Awel y Môr Offshore Wind Farm

Planning Inspectorate reference:
EN010112

Summary of Written Representation
for Examination Deadline 1 by
Gwynedd Archaeological Planning Service

24th October 2022

Drawing file: published-documents / EN010112-000370-6.6.10.5.7_AyM_SLVIA_Fig_34a-h_VP7_Penmon_Point_-_north-east_of_parking.pdf

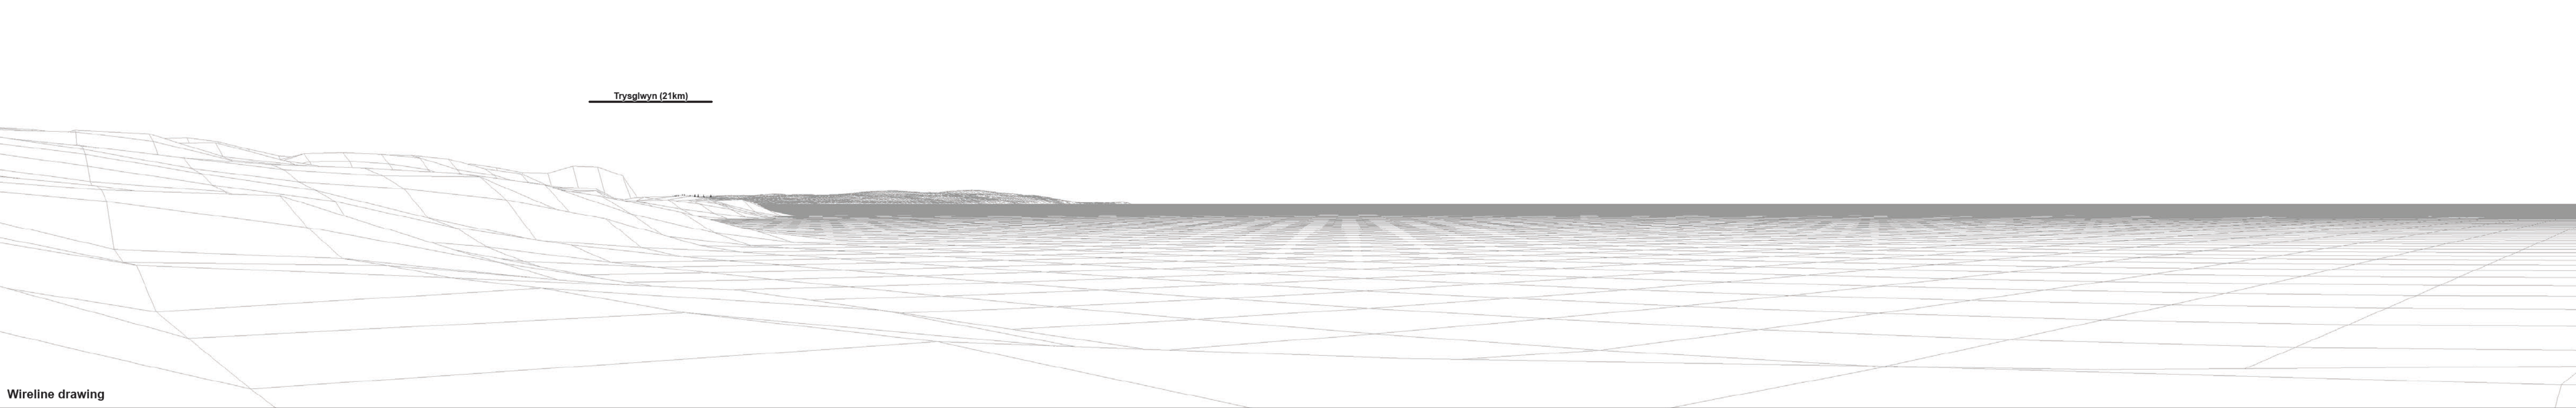
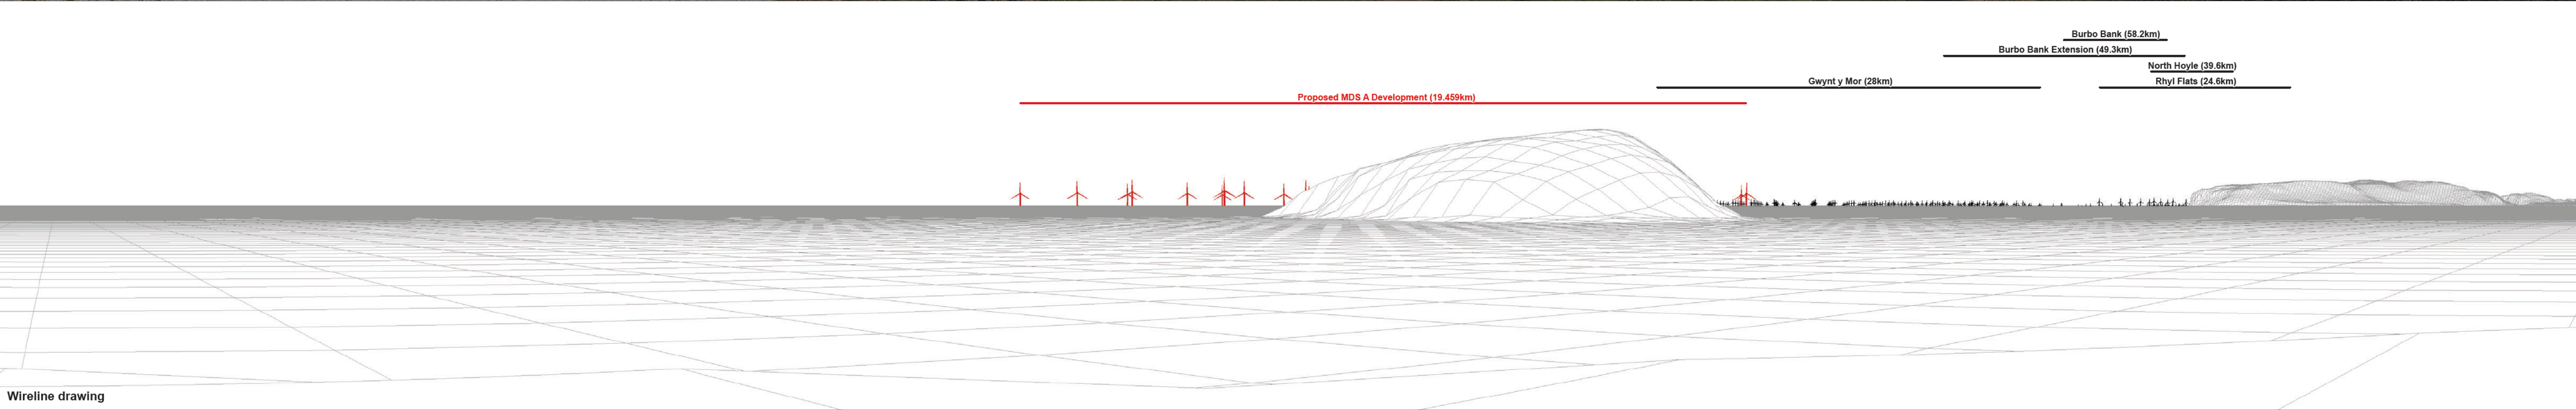
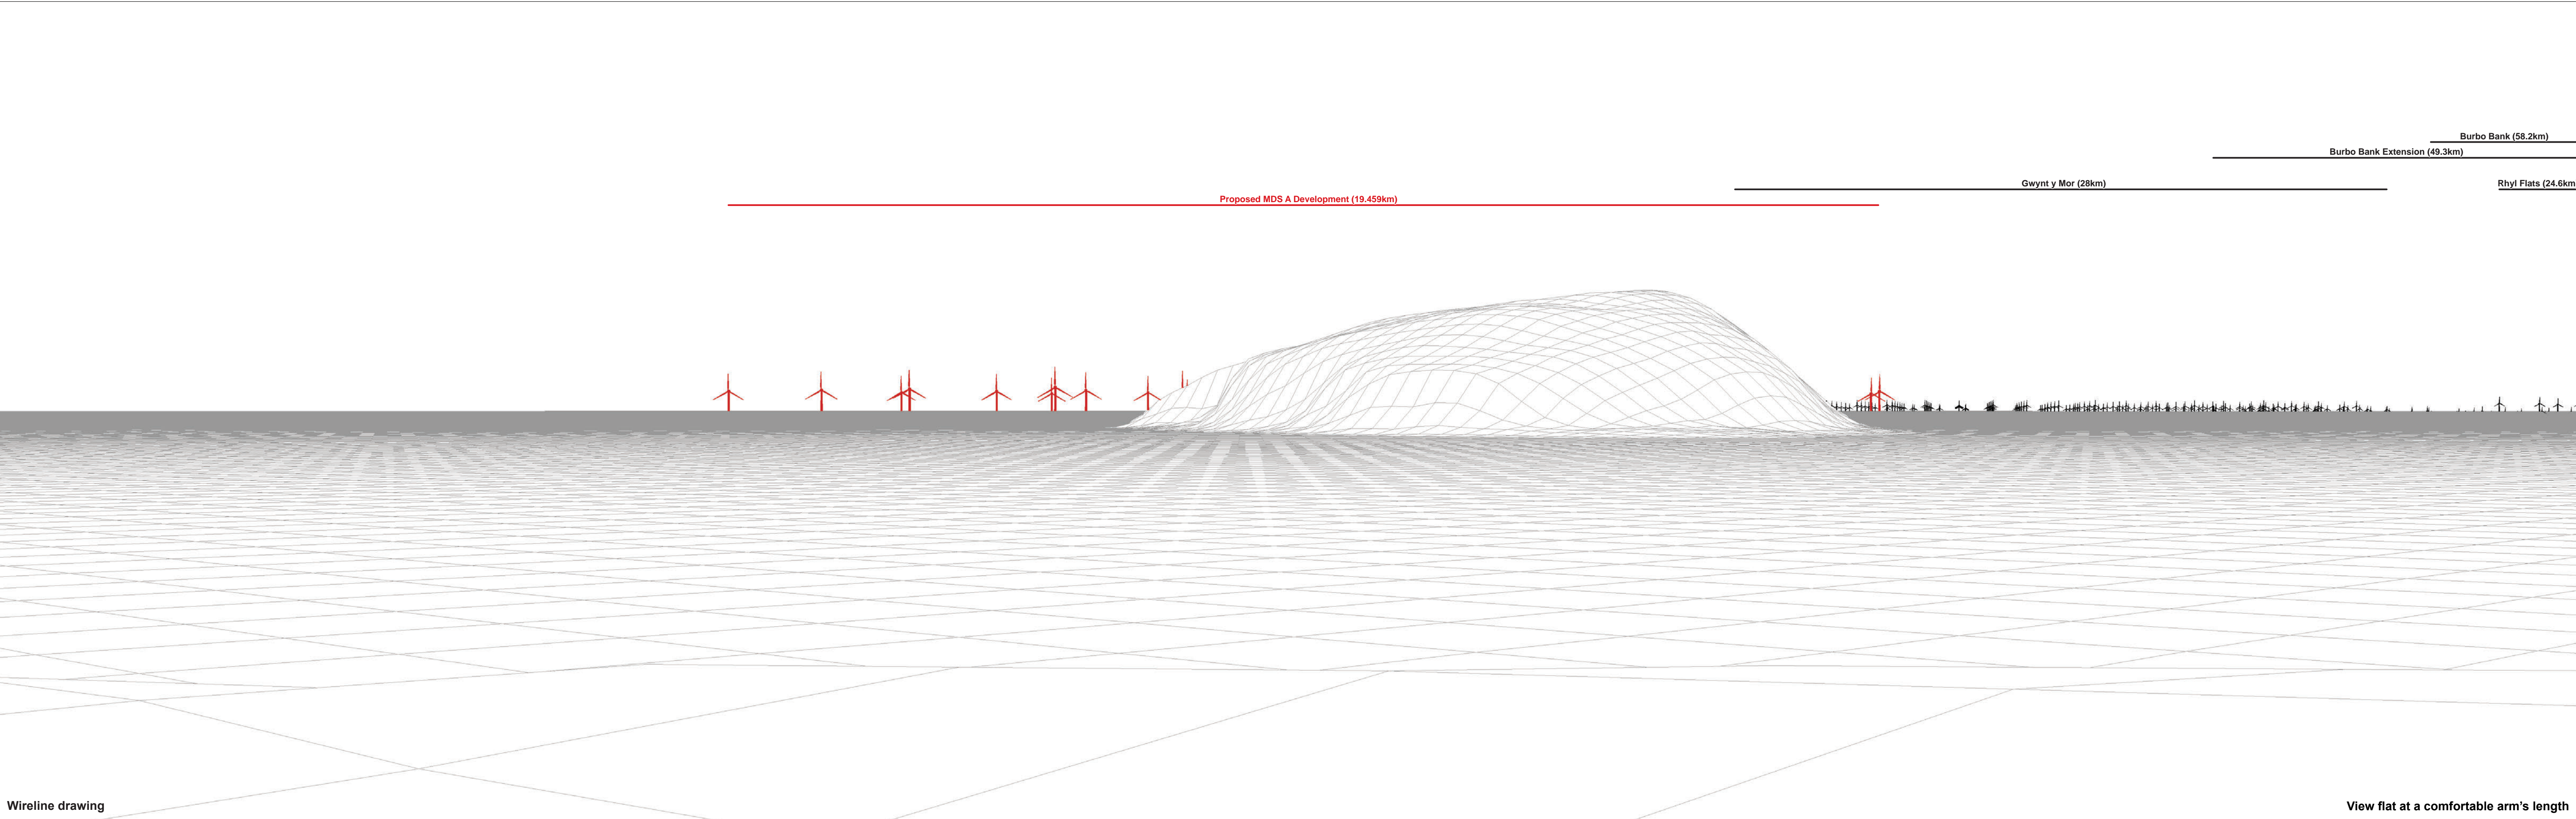
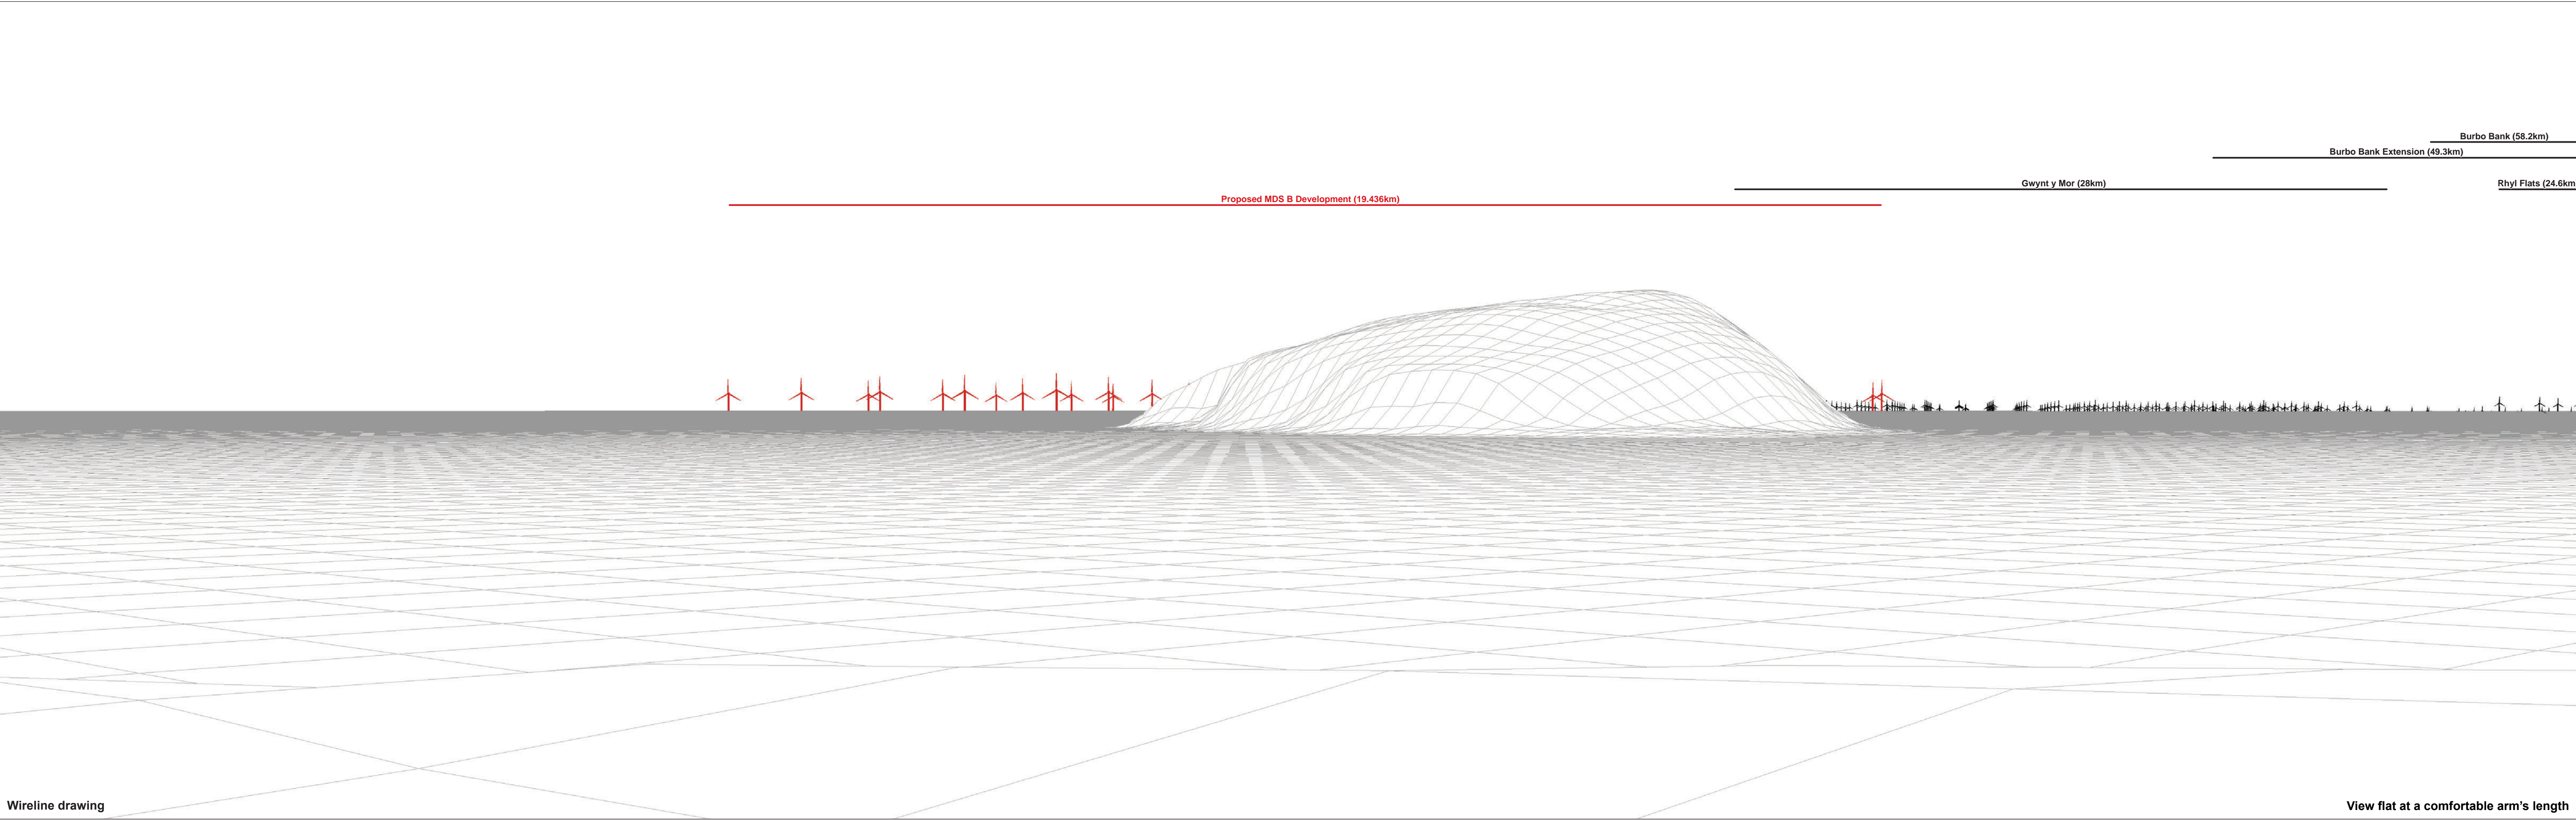
- 2.59 The assessment notes that the new wind turbines would be visible either side of Puffin Island in VP7 (Volume 6, Annex 10.5, Fig.34) but are clearly separate and do not challenge the island for prominence (paragraph 302). As discussed above in relation to Scheduled Monument AN064 (Grade I Listed Building 5528), the juxtaposition of turbines in this view nonetheless reduces the sense of place as a remote monastic site, and this is even more stark from VP8. This impact was assessed as of moderate significance at an individual level.
